Construction Drawings (PlansProfiles)_v1.pdf Markup Summary

8-29-2022

Cursory comments

ROAD IMPROVEMENT PLANS

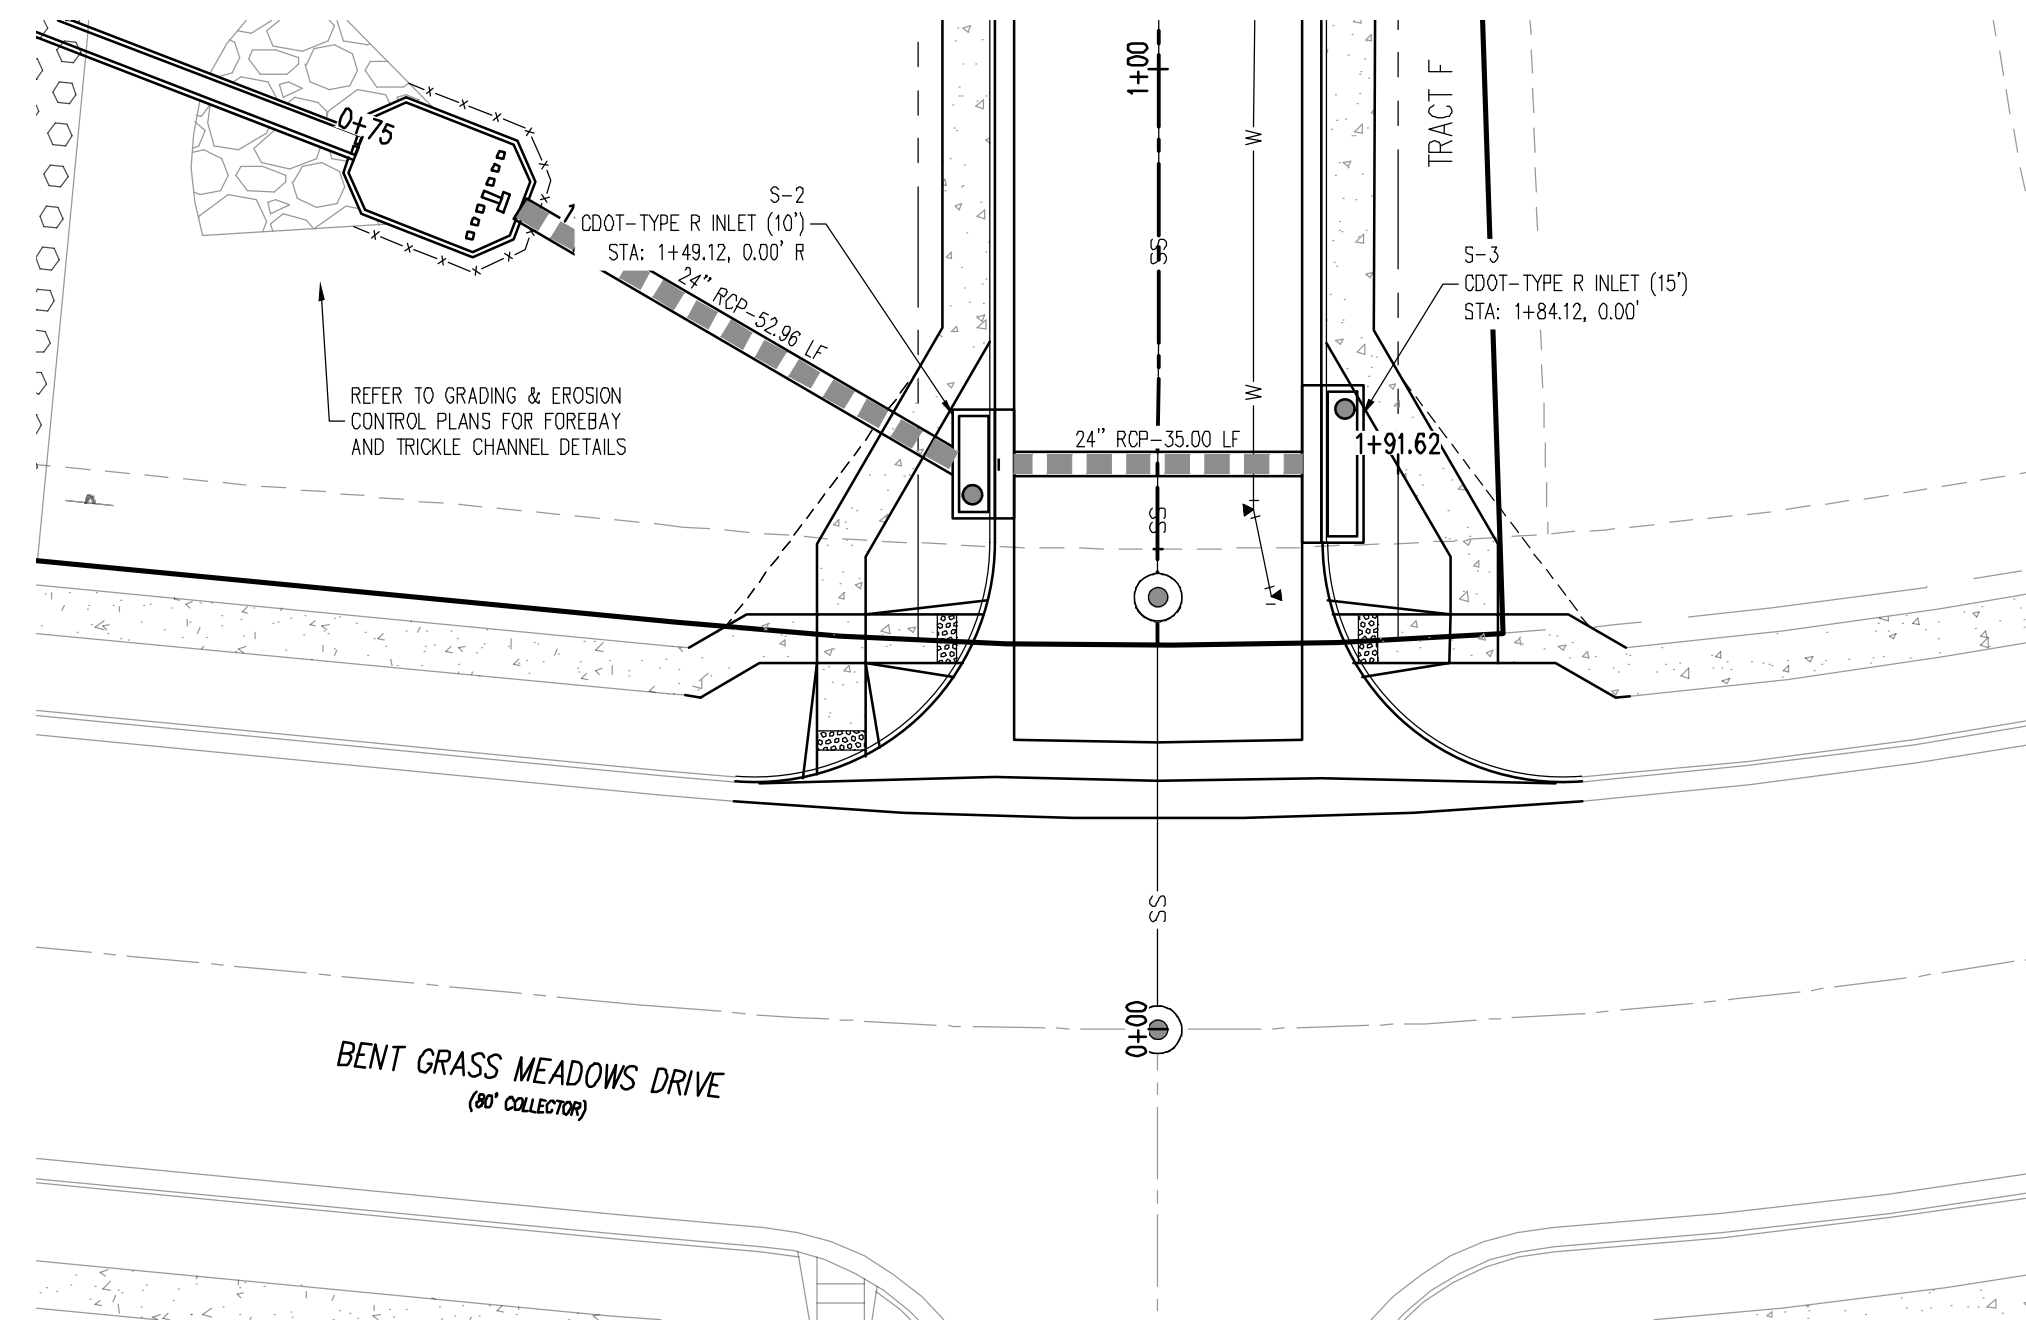
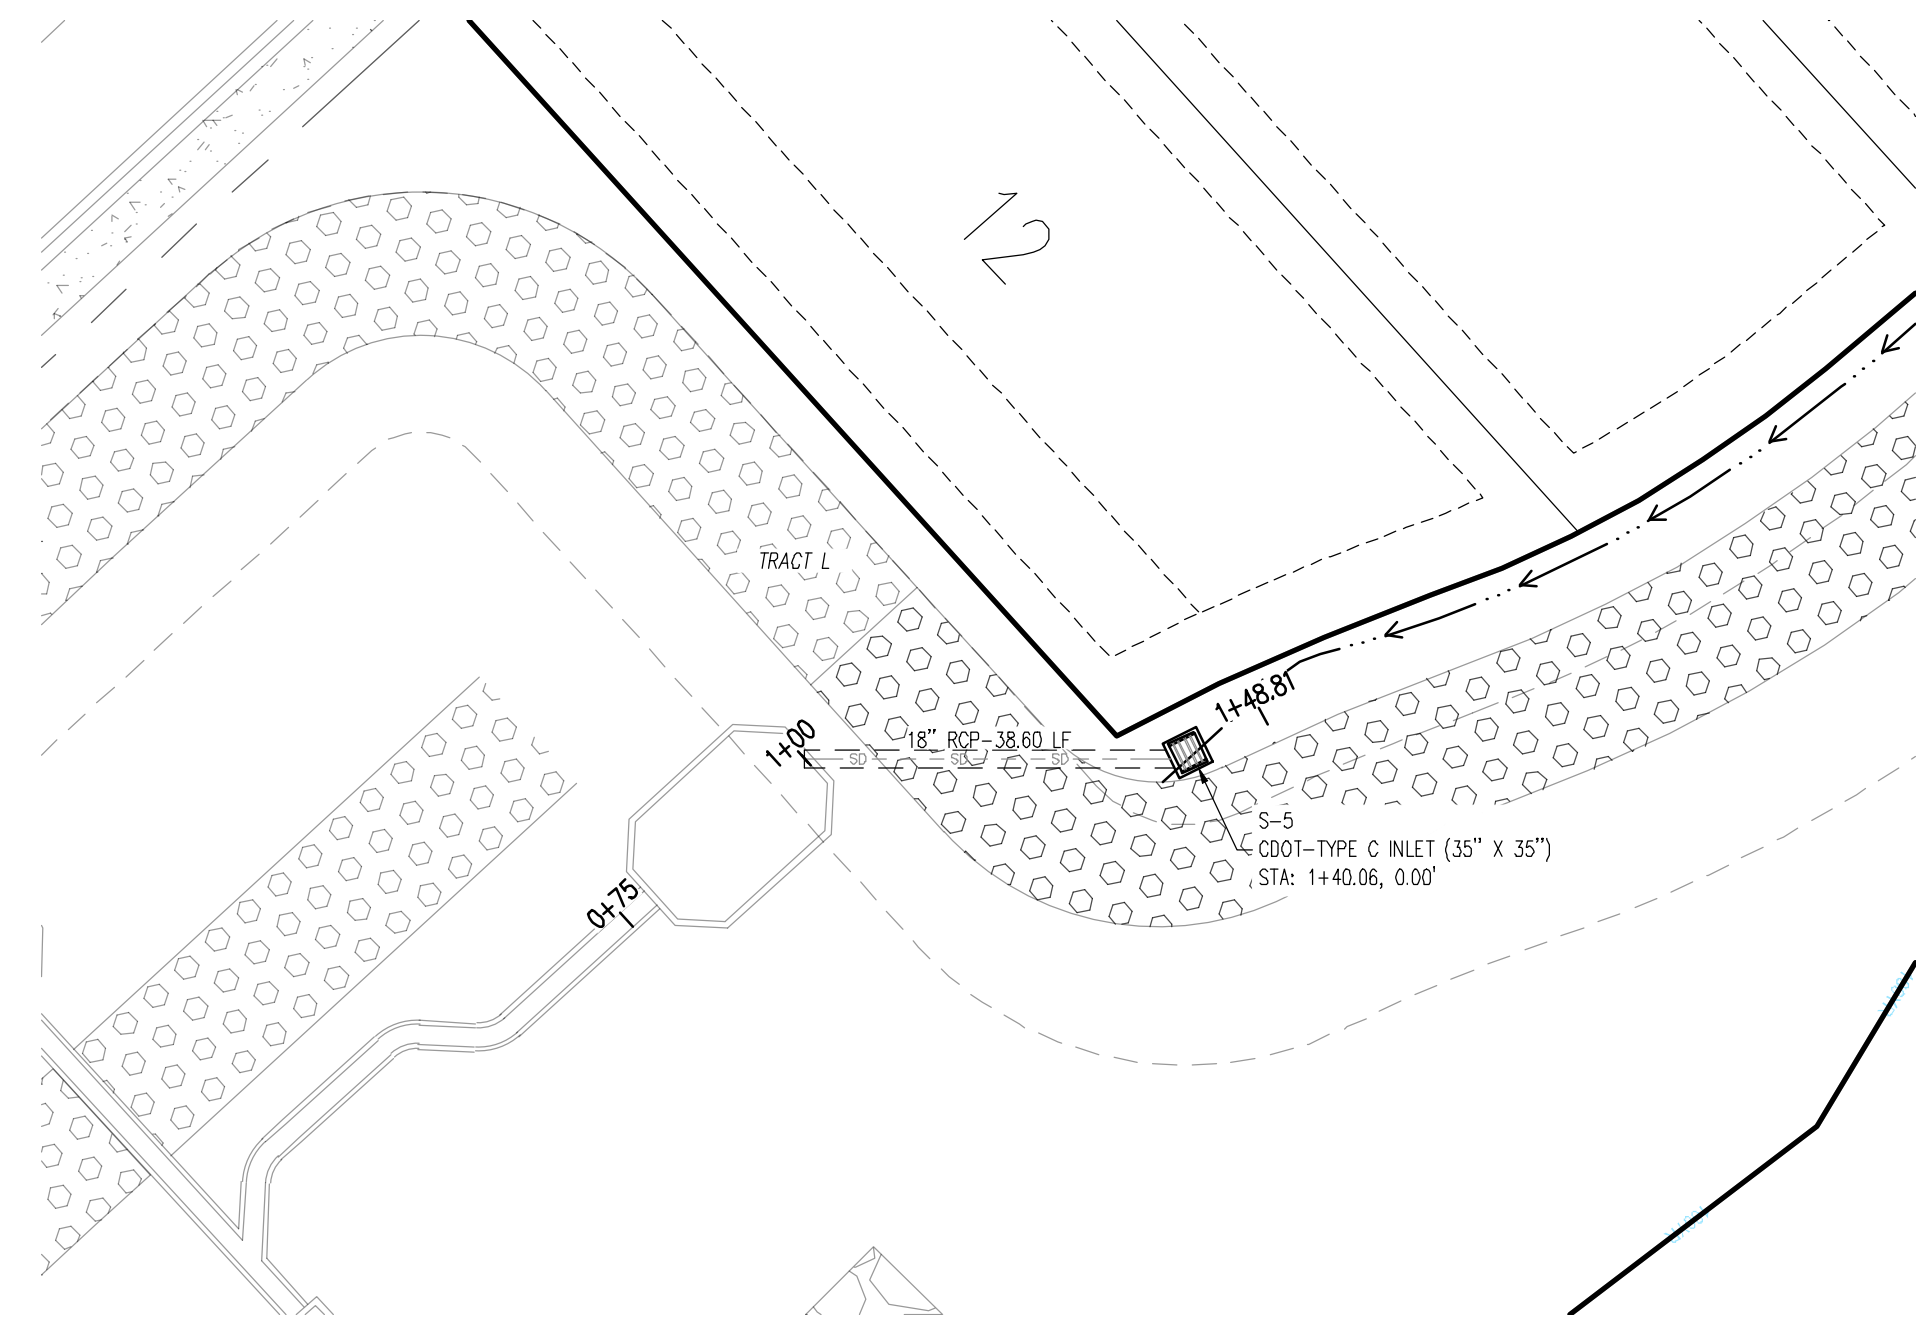
Subject: Callout
Page Label: [8] 8 STORM DRAIN PLAN & PROFILE Show and label HGL and Q5 and Q100
Author: dsdrice
Date: 8/19/2022 1:38:30 PM
Status:
Color: ■
Layer:
Space:

Subject: Callout
Page Label: [8] 8 STORM DRAIN PLAN & PROFILE Show forebay
Author: dsdrice
Date: 8/19/2022 1:39:14 PM
Status:
Color: ■
Layer:
Space:

**SIGNAGE PLAN**

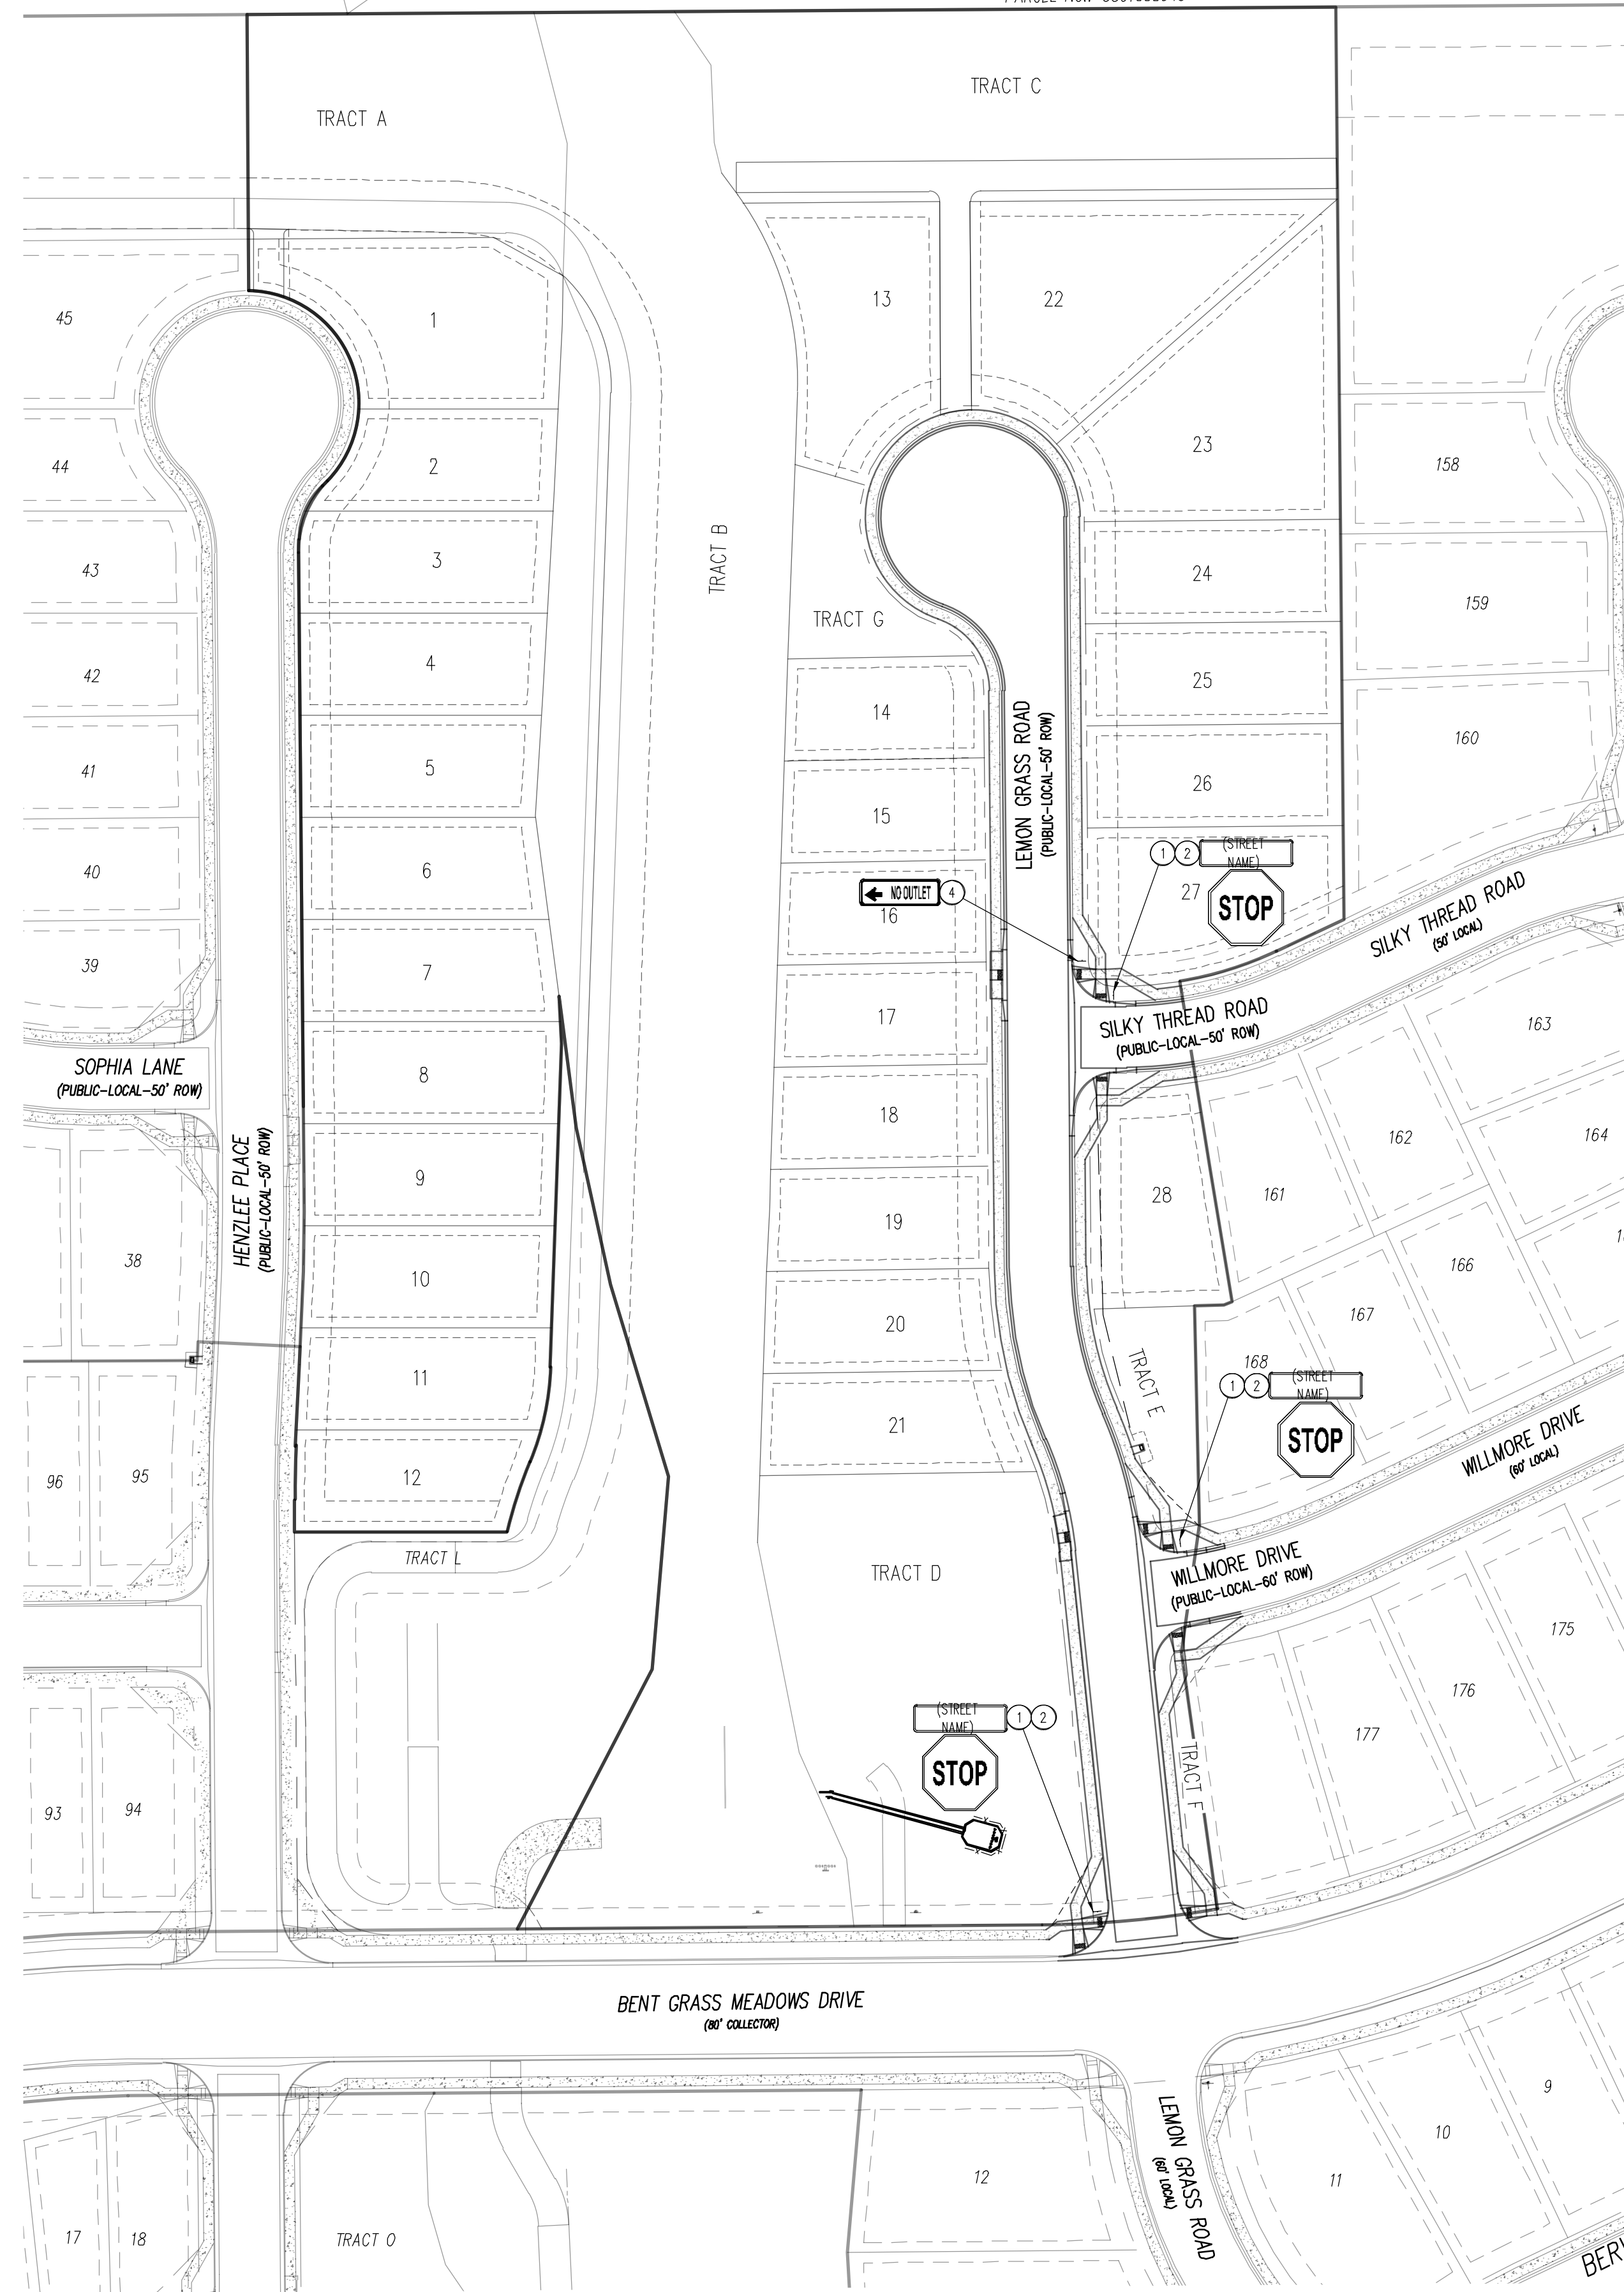
Stop sign?
